# CITY OF ALBUQUERQUE

January 23, 2018

**Re: Springhill Suites  
Central and Mulberry  
For DRB Approval**  
Engineer's/Architect's Stamp **XX-XX-XX** (K15-D034B)

SITE PLAN

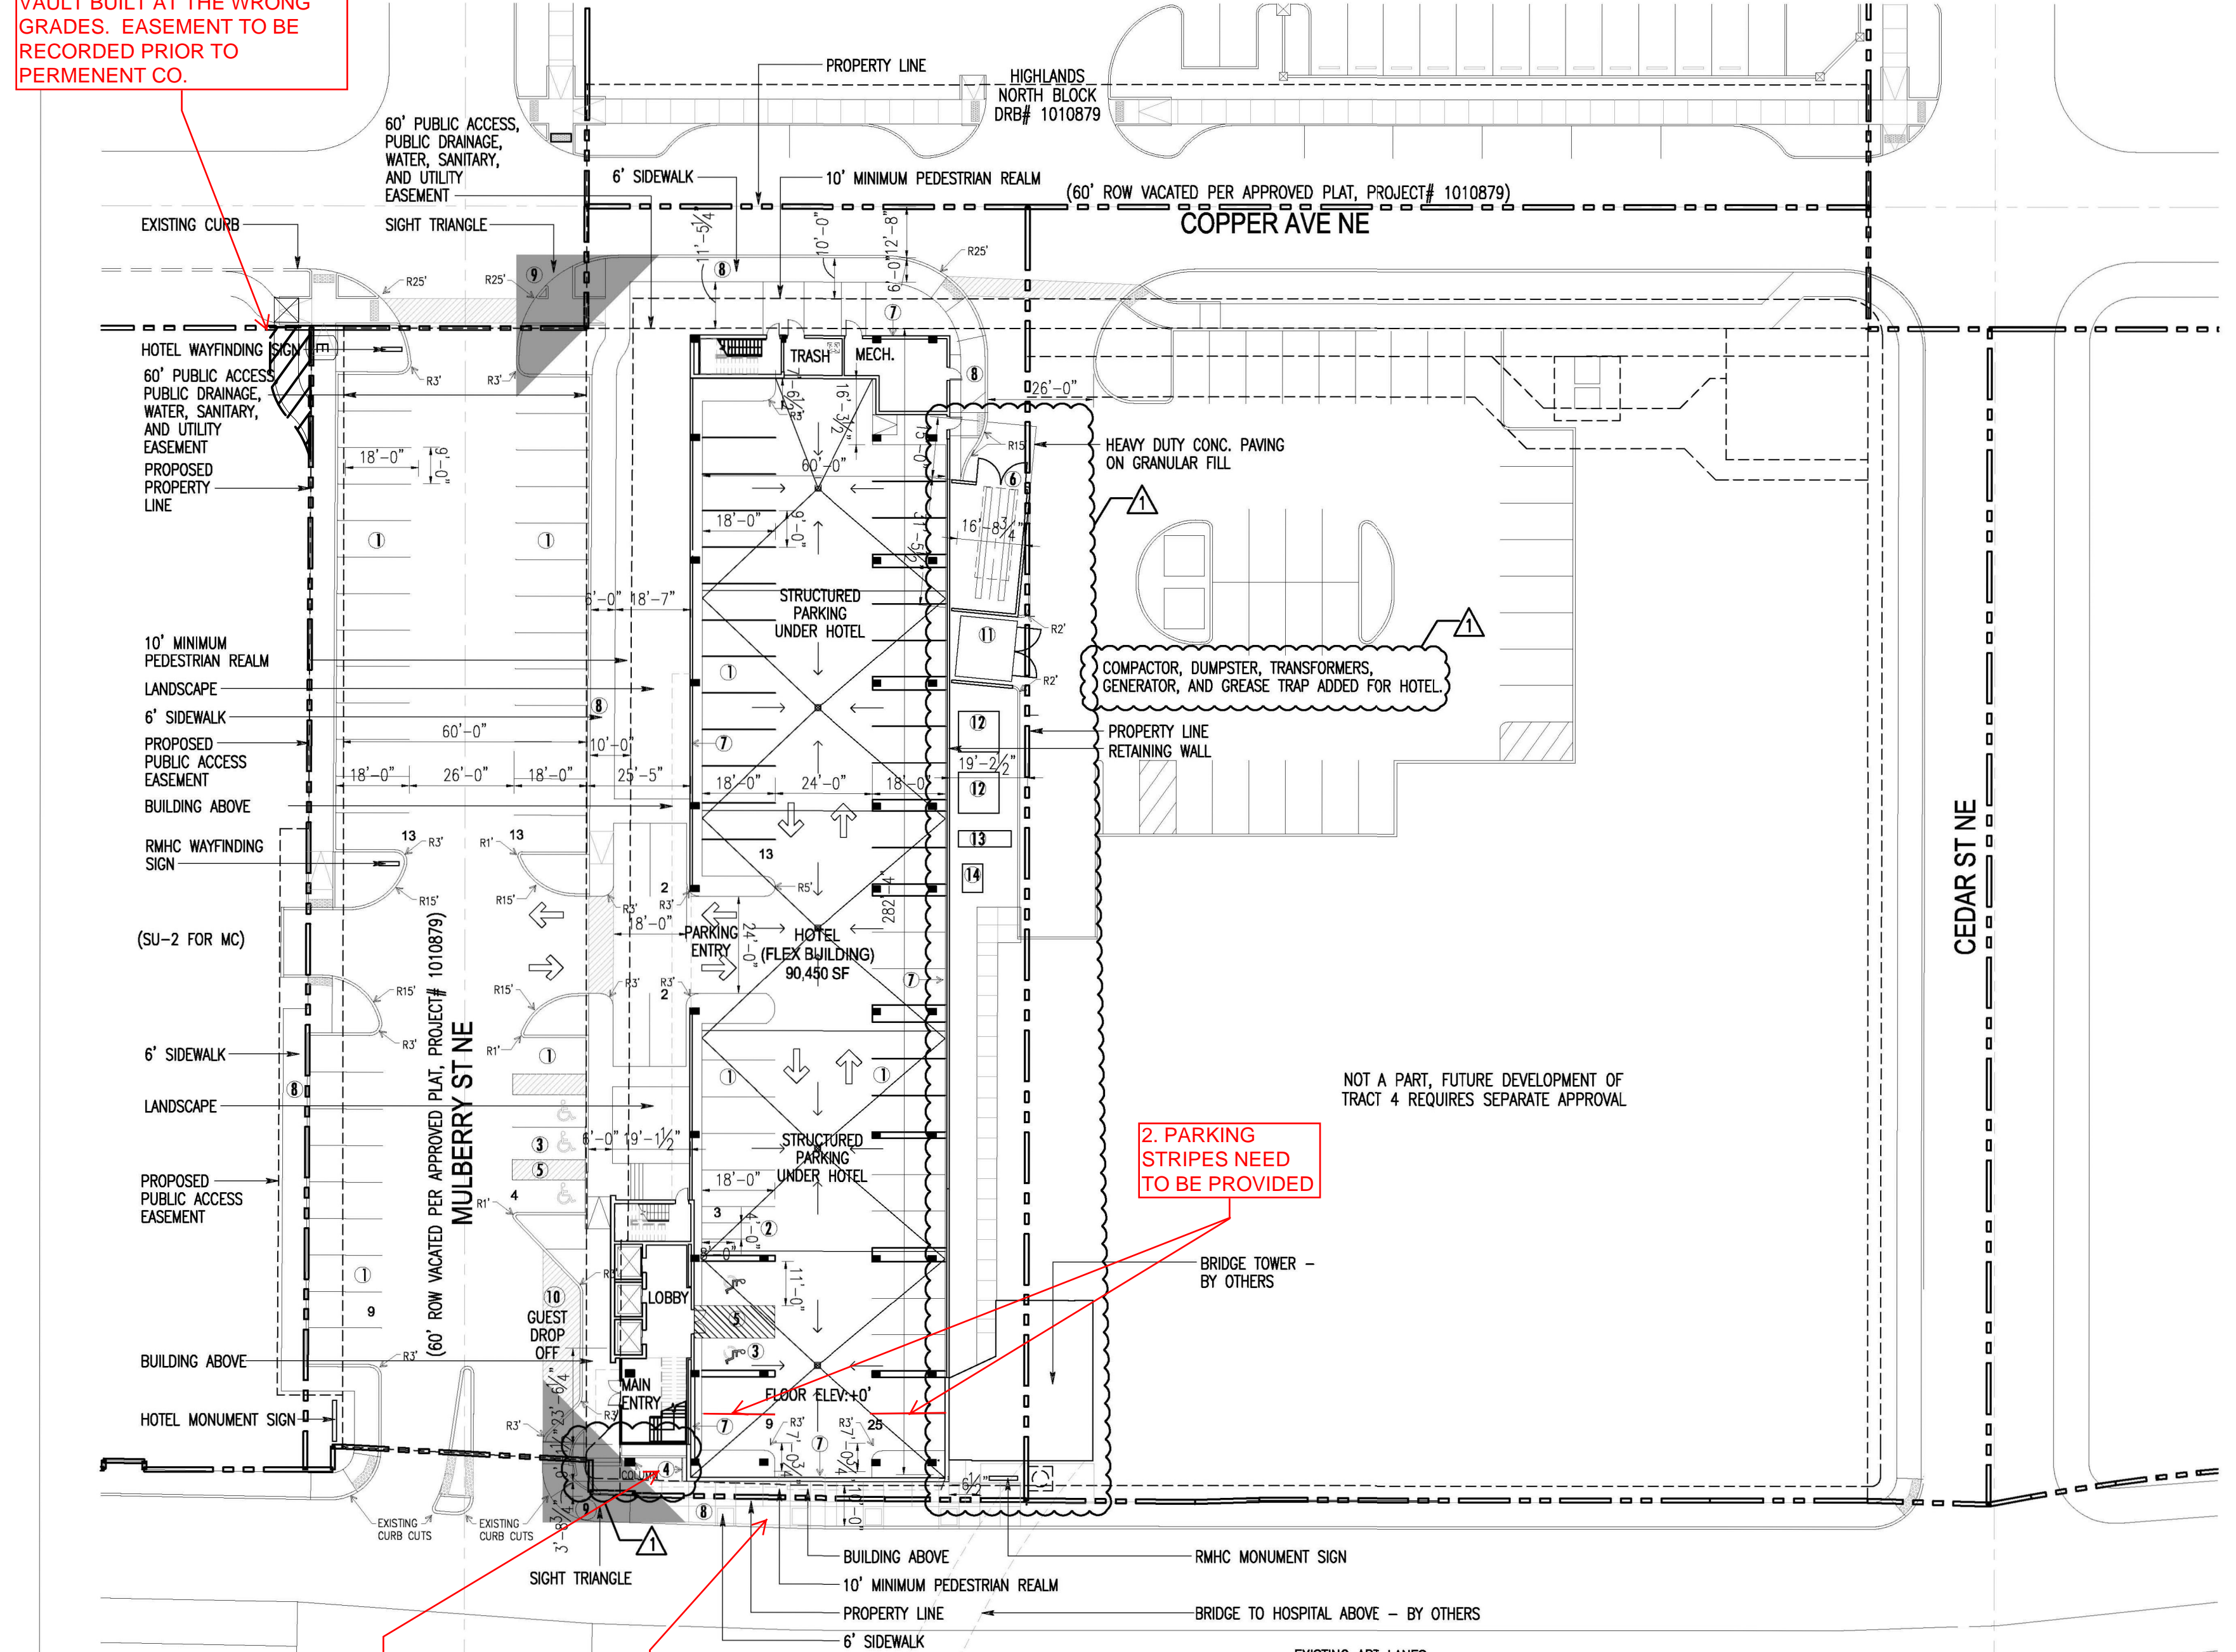
1. The ADA parking spaces on Mulberry must have ADA access ramps to the sidewalk.
2. Motorcycle parking spaces shall be designated by its own conspicuously posted upright sign, either free-standing or wall mounted per the zoning code.
3. Please consider the 4 parking spaces at the entrance of the under building parking. This may create conflicts for vehicles entering and exiting.
4. List radii for all curves shown; for passenger vehicles, the minimum end island radius for passenger vehicles is 15 ft. Radius for delivery trucks, fire trucks, etc. is 25 ft. or larger.
5. The south clear sight triangle should be 25 X 25 feet.
6. Show the bicycle rack on the site plan.
